**From:** Graham Astley (CSP - Local Environment)  
**Sent:** 12 September 2016 17:42  
**To:** Kevin Straw (CSP - Development Control)  
**Cc:** Louise Williams (CSP - Development Control)  
**Subject:** P/2016/0921 - Outline for a dwelling on land adjacent Rock House, Llanllwchaiani, Newown

Thanks for consulting the Lead Local Flood Authority (LLFA).

SEWER RECORD Land at Rock House, Rock Farm U2624 From Dolfor Farm To Junction With Road To Ro, Y
Drenewydd, SY16 3BH

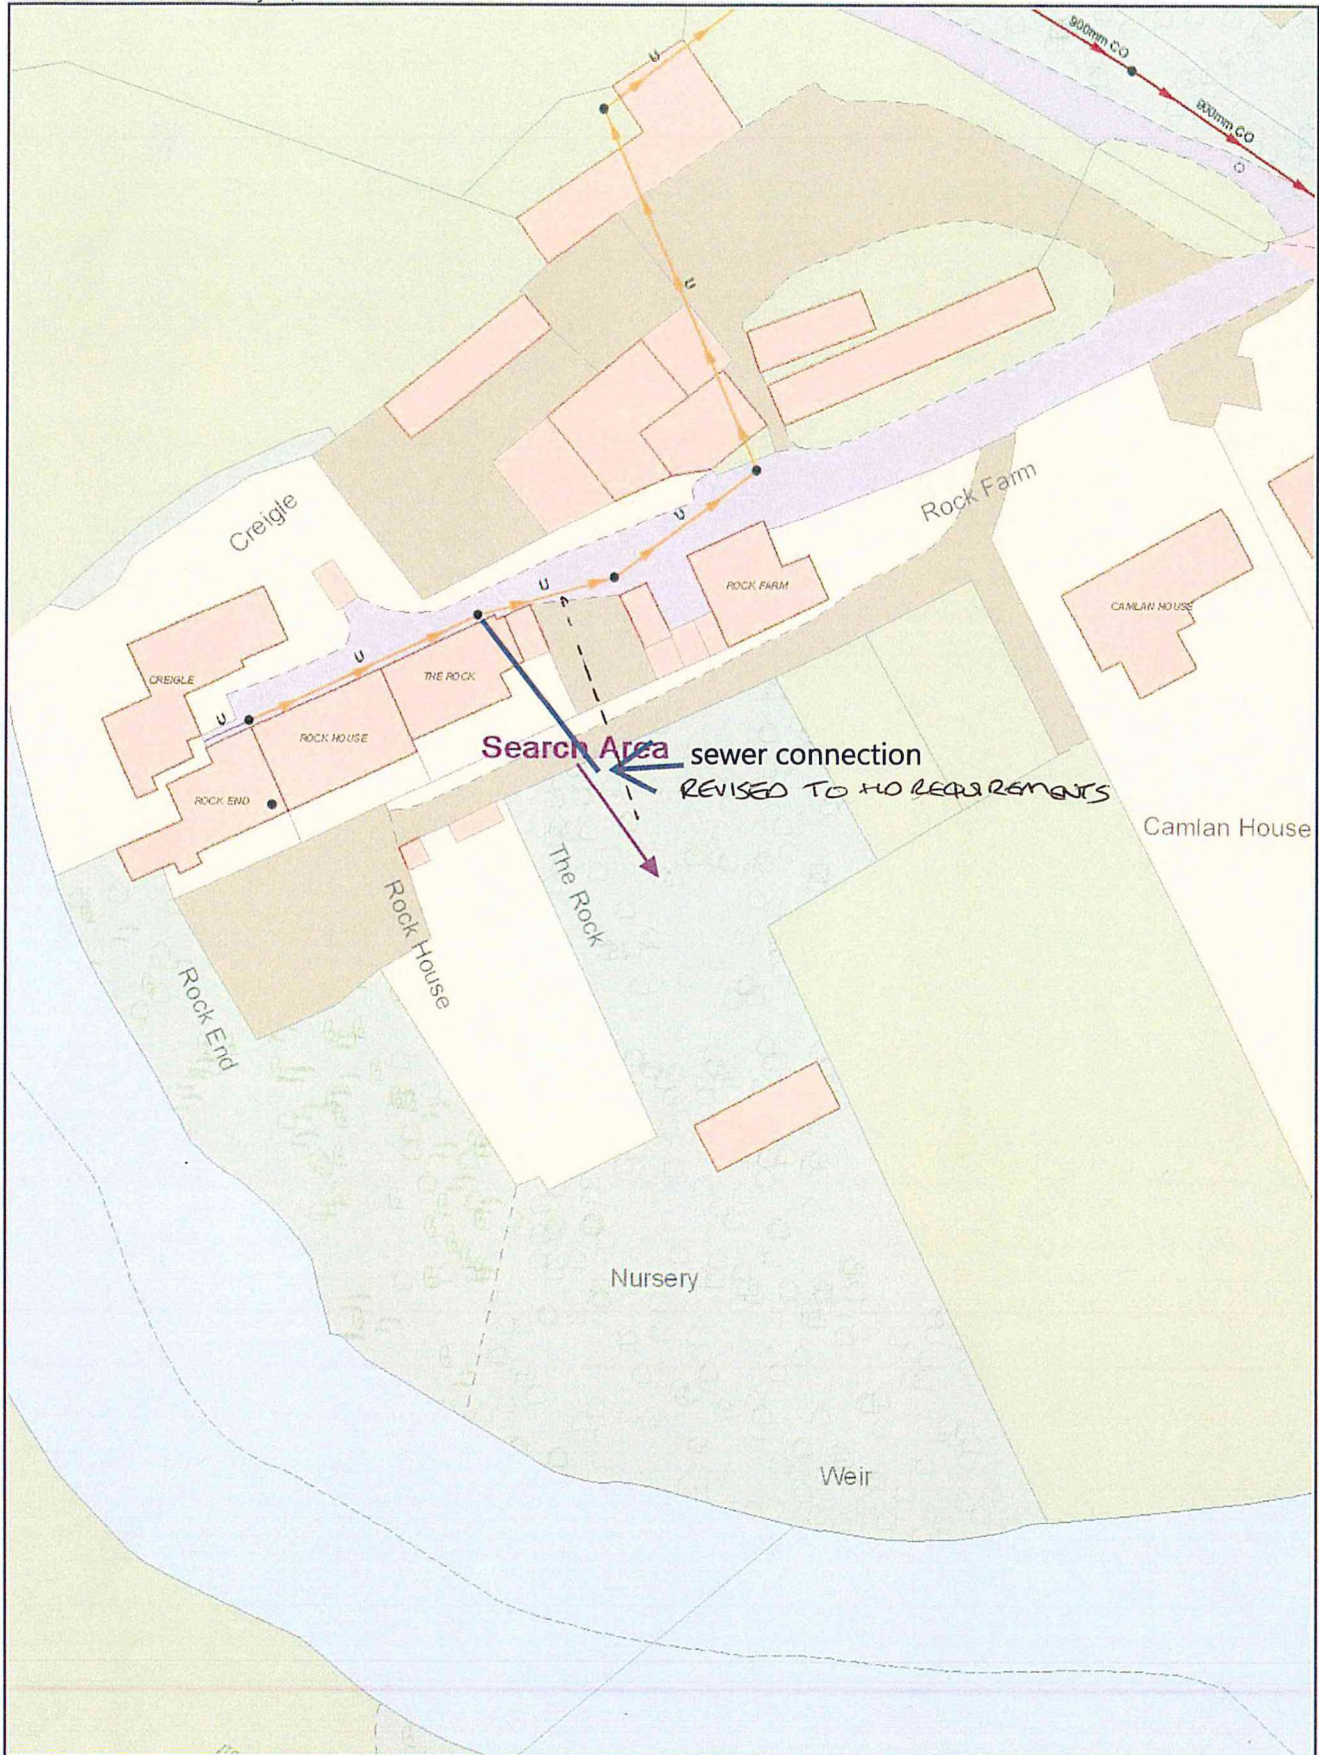
**Environment Protection** - Foul drainage from the proposed development should be conveyed to the main foul sewer, subject to the agreement by Severn Trent Water Ltd. There must be adequate capacity at the receiving sewage treatment works to treat the additional flows.
